Right of Light Consulting

Application Reference No. 2023/90444/W

**Proposed Development at Land Adjacent 39 Far End Lane, Honley, Holmfirth, West Yorkshire HD9 6NS
Impact on Quarry House, 18 Woodhead Road, Honley, Holmfirth, West Yorkshire HD9 6PP**

North Elevation - 1:100

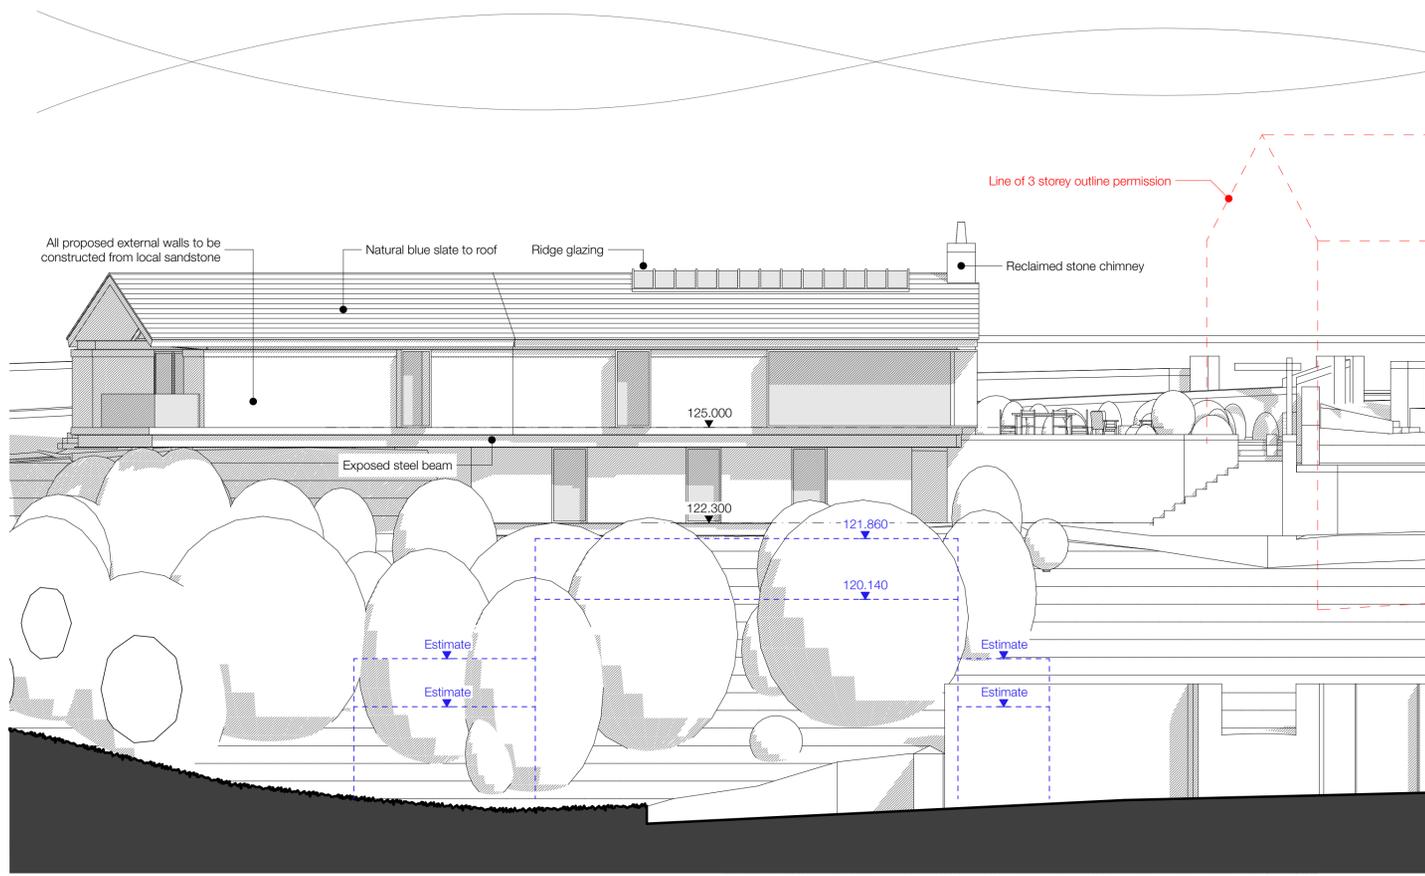
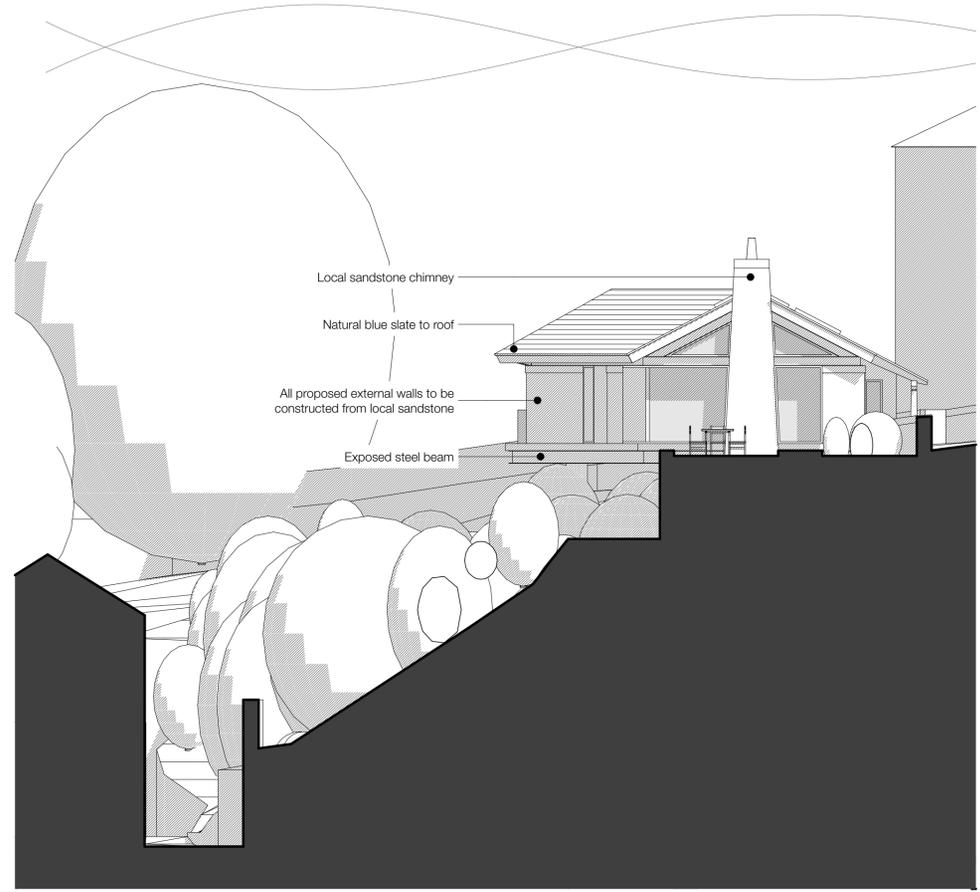
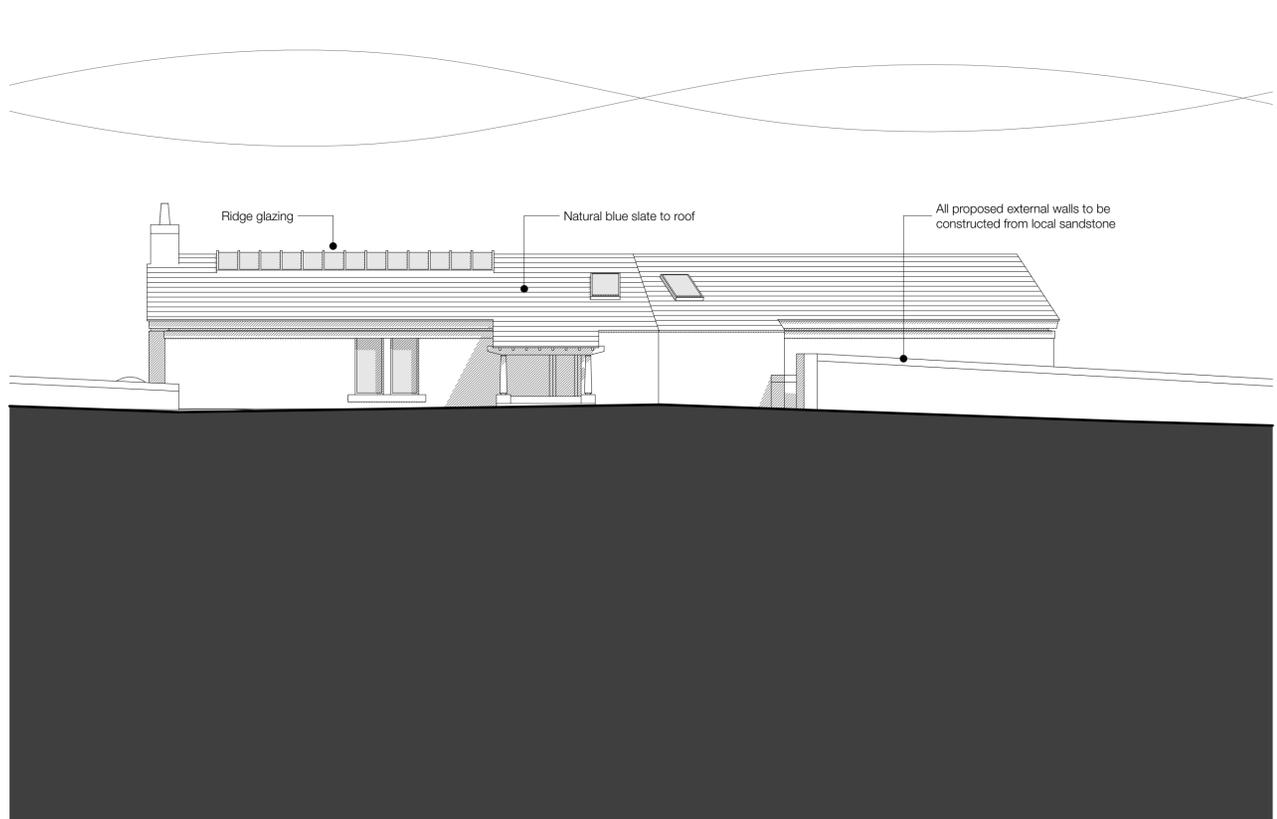
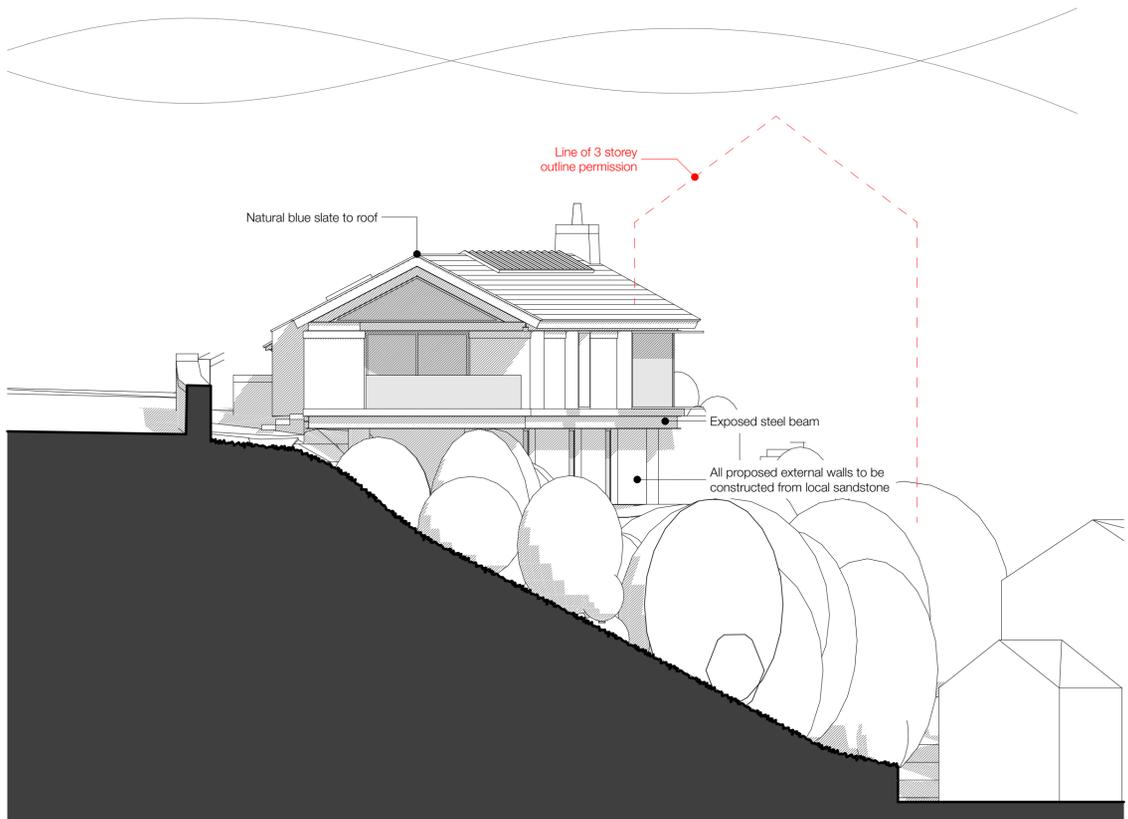
Due to the elevated position of the site and its proposed layout, loss of privacy and the domineering impact of the proposed dwelling are also important concerns of our clients. It is noted that Quarry House is not shown on the applicants North Elevation plan, and we understand that our clients have reasonably requested the applicant address this omission and provide an updated plan.
